Change of Use from Shop (A1 Shops) to Dwelling (C3 Dwellinghouses) - This application may affect the character and appearance of Arundel Conservation Area.

107A Tarrant Street Arundel

Thank you for your internet representation made on 15th November 2019 which has been recorded as '**no objection**' with the comments as follows:

GROUND FLOOR PLAN

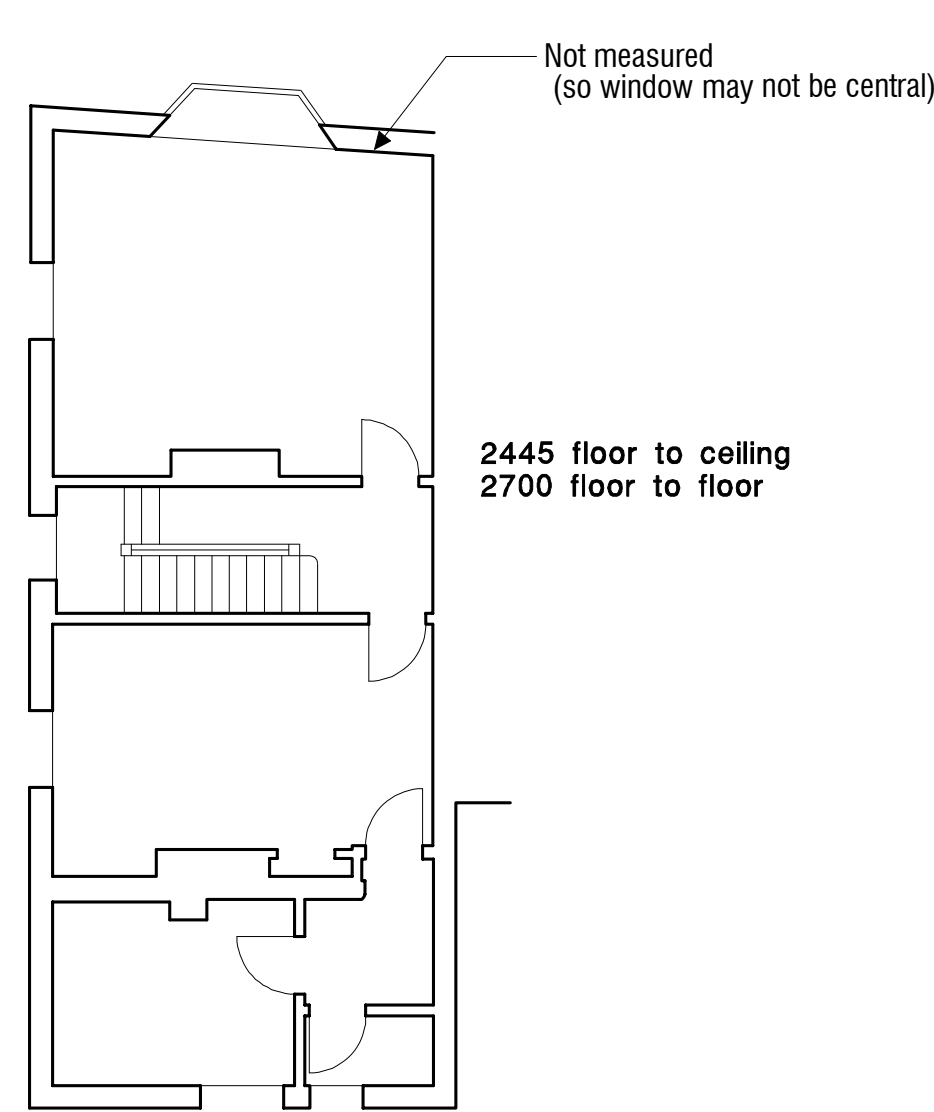
It is suggested that consideration ought to be given at an early stage as to whether or not the requirements of the Building Regulations will require alterations to the existing shopfront if residential use is permitted. If it is the case that alterations are necessary then it is recommended that a condition be attached to any planning permission requiring the submission of precise details of any alterations proposed.
